City of Albuquerque Stormwater Construction Site Inspection Report

General Information						
Project Name:	PresNowCoors					
Location:	4515Coors					
Site Contact Name & Agency	Jan Nakotte - Jaynes-345-8591	ESC File No.	F11E019			
	jann@jaynescorp.com	NPDES Id. No.	NMR1001XU			
Inspection Date:	03/21/19	Start/End Time:	1145/1300hrs			
CoA Stormwater Inspector:	Timothy Sims, Stormwater Inspector					
Present Phase of Construction:	clear & grub, over ex.					
Type of Inspection:	<input checked="" type="checkbox"/> Regular	<input type="checkbox"/> Storm Event	<input type="checkbox"/> Post Storm Event >0.25"	<input type="checkbox"/> 311/Complaint	<input type="checkbox"/> Follow Up	
Weather at time of inspection?			Temperature: ~ 49			
Windy

EROSION AND SEDIMENT CONTROL PLAN

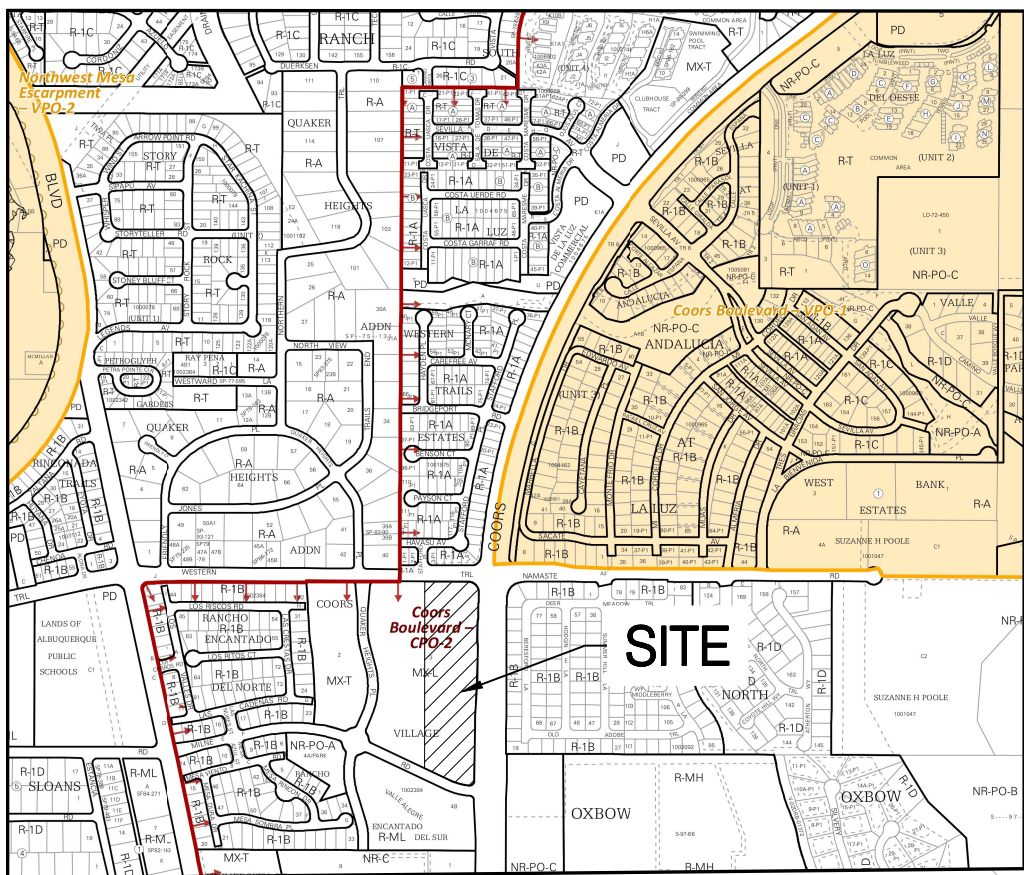
2.2.1	Provide and maintain Natural buffer when Waters of the US <50ft.		
2.2.3	Sediment control along any perimeter	x	install perimeter BMP per plan
2.2.3	Sediment control along any perimeter	x	install trackout pad

2.2.3	Sediment control along any perimeter	x	trackout on Western Trails form entrance to Quaker Heights
2.2.3	Sediment control along any perimeter		
2.2.3	Sediment control along any perimeter

2.2.14	Stabilize exposed portions of the site		
2.3.1	Equipment and vehicle fueling		
2.3.2	Equipment and vehicle washing		
2.3.3	Building material storage	X	ensure spill kit is on site

2.3.3	Fuel, oil, hydraulic fluid, petroleum products and chemical storage		
2.3.3	Construction and domestic wastes	X	refuse containers are required to have the ability to be covered when not in use

Notes:	earth moving activities started prior to BMP's being installed.

Maintenance or corrective actions are to be completed within seven (7) days.
